# IS-FBC: Building Design Standards (BDS)

Complies	More Info	Does Not Comply	N/A	Comments
<b>BUILDING DESIGN STANDARDS (BDS)</b>					Review (2/17/16) Caitlin Cameron, Rick Knowland, Jean Fraser
<b>1. Neighborhood Context</b>					
Intent	<input checked="" type="checkbox"/>	<input type="checkbox"/>	<input type="checkbox"/>	<input type="checkbox"/>	
Guidelines	<input type="checkbox"/>	<input checked="" type="checkbox"/>	<input type="checkbox"/>	<input type="checkbox"/>	The material palette appears dark compared to the context – samples? The review panel was concerned about the building in context of Hampshire Street, attention should be given to those parts of the building visible from the street.
<b>2. Massing &amp; Proportion</b>					
Intent	<input type="checkbox"/>	<input type="checkbox"/>	<input checked="" type="checkbox"/>	<input type="checkbox"/>	The panel is concerned about the scale of the garage façade on Franklin – the proportion of the garage to the overall building is quite tall and very little makes the two-story wall comfortable at pedestrian scale.

**A201**

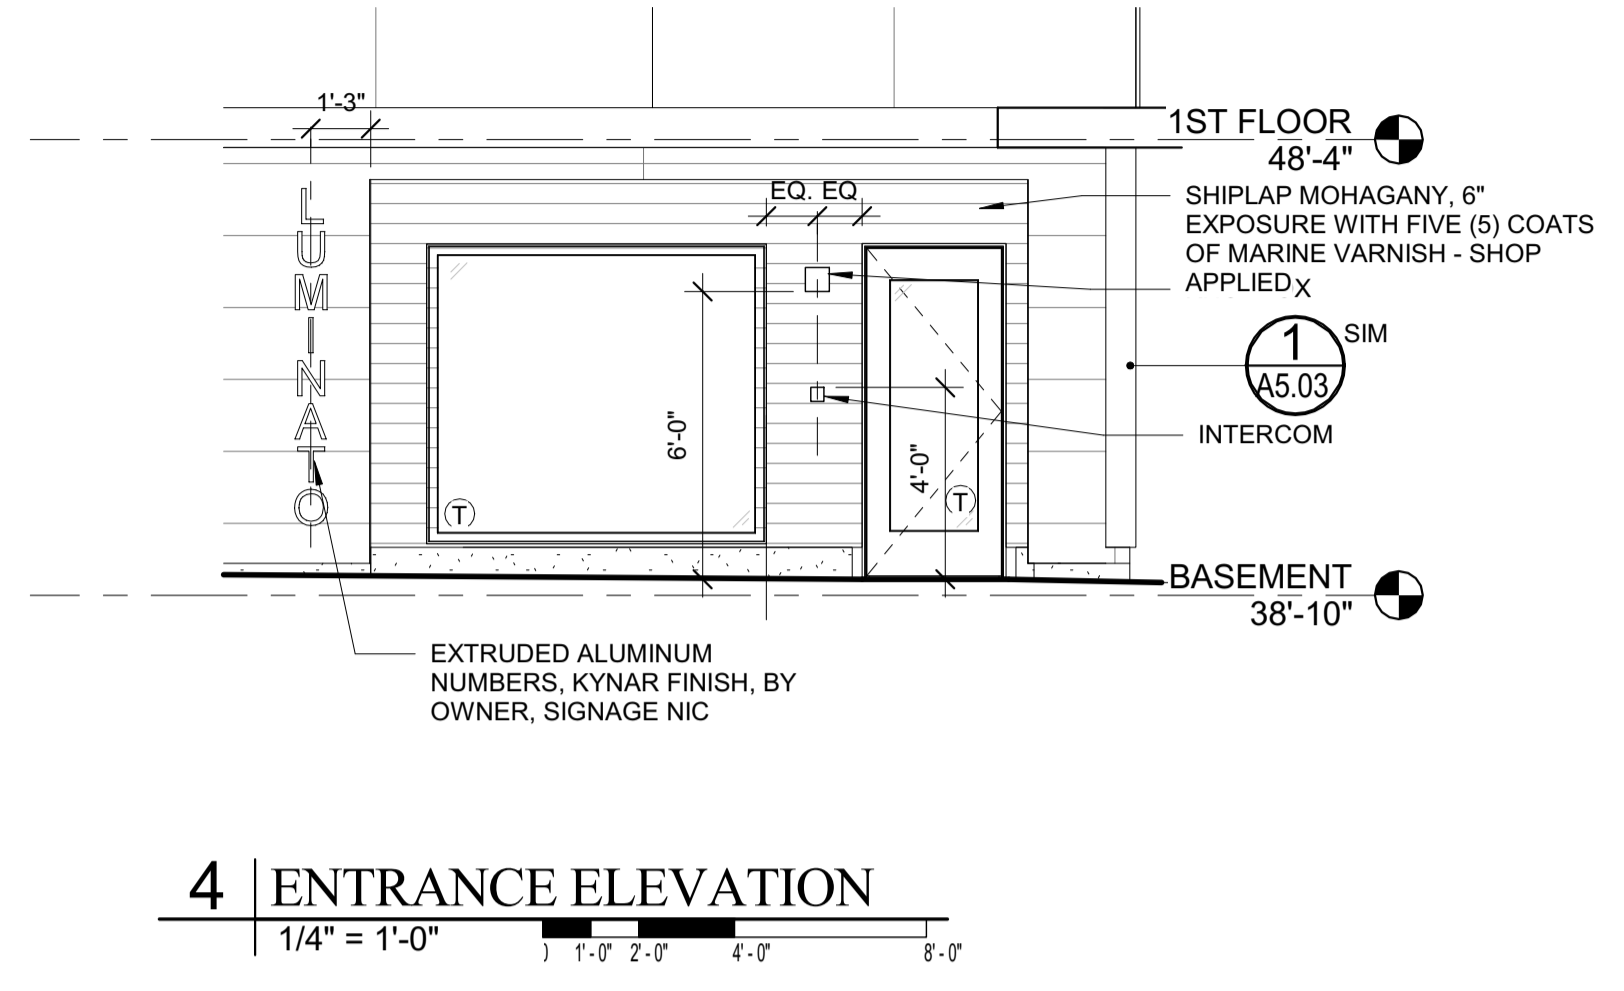
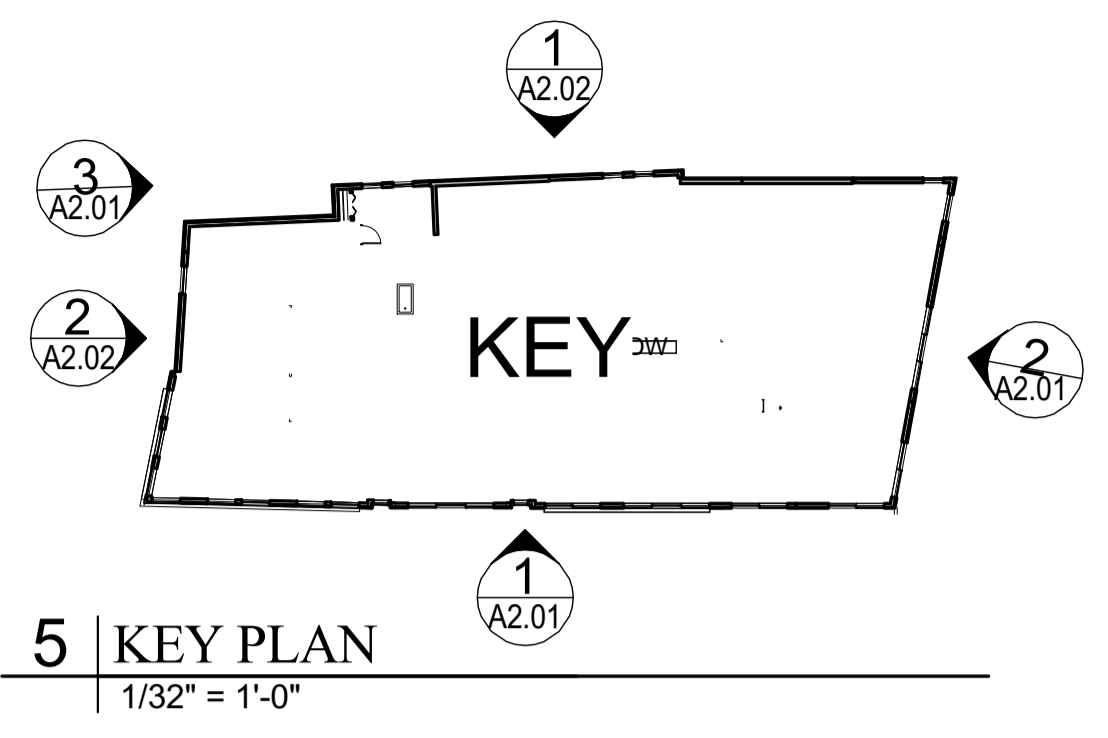
Guidelines	<input type="checkbox"/>	<input type="checkbox"/>	<input checked="" type="checkbox"/>	<input type="checkbox"/>	Bring more emphasis to the corner: see sketch attached for notes. The stepbacks help to mitigate the scale of the new, large building compared with the smaller context. Stepback at back corner would alleviate the scale and height impacts for the 2 and 3-story buildings.
Standard 2.1	<input type="checkbox"/>	<input type="checkbox"/>	<input type="checkbox"/>	<input checked="" type="checkbox"/>	
<b>3. Articulation &amp; Composition</b>					
Intent	<input type="checkbox"/>	<input type="checkbox"/>	<input checked="" type="checkbox"/>	<input type="checkbox"/>	The Franklin garage façade does not, yet, meet the articulation standards.
Guidelines	<input type="checkbox"/>	<input type="checkbox"/>	<input checked="" type="checkbox"/>	<input type="checkbox"/>	
Standard 3.1: 3 required	<input type="checkbox"/>	<input type="checkbox"/>	<input checked="" type="checkbox"/>	<input type="checkbox"/>	This standard is not met for the garage façade: see comments in Section 8

Standard 3.2	<input checked="" type="checkbox"/>	<input type="checkbox"/>	<input type="checkbox"/>	<input type="checkbox"/>	
Standard 3.3: Blank Wall	<input type="checkbox"/>	<input type="checkbox"/>	<input checked="" type="checkbox"/>	<input type="checkbox"/>	Franklin garage façade – more articulation is requested to break up the blank wall.

Standard 8.1	<input type="checkbox"/>	<input type="checkbox"/>	<input checked="" type="checkbox"/>	<input type="checkbox"/>	The review panel feels this standard is not yet met – there is a lack of articulation and visual interest on a long and prominent façade. Suggestions: carry the plane changes all the way down the façade; bring the cladding material further down the façade; incorporate openings or windows into the upper parking deck; chose a base material color that better relates to the upper floors; incorporate lighting; incorporate landscaping. The panel was especially concerned with CPTED when it comes to visibility and safety along this façade. Refer to the sketch for further notes and clarification.
Standard 8.2	<input checked="" type="checkbox"/>	<input type="checkbox"/>	<input type="checkbox"/>	<input type="checkbox"/>	
Standard 8.3	<input checked="" type="checkbox"/>	<input type="checkbox"/>	<input type="checkbox"/>	<input type="checkbox"/>
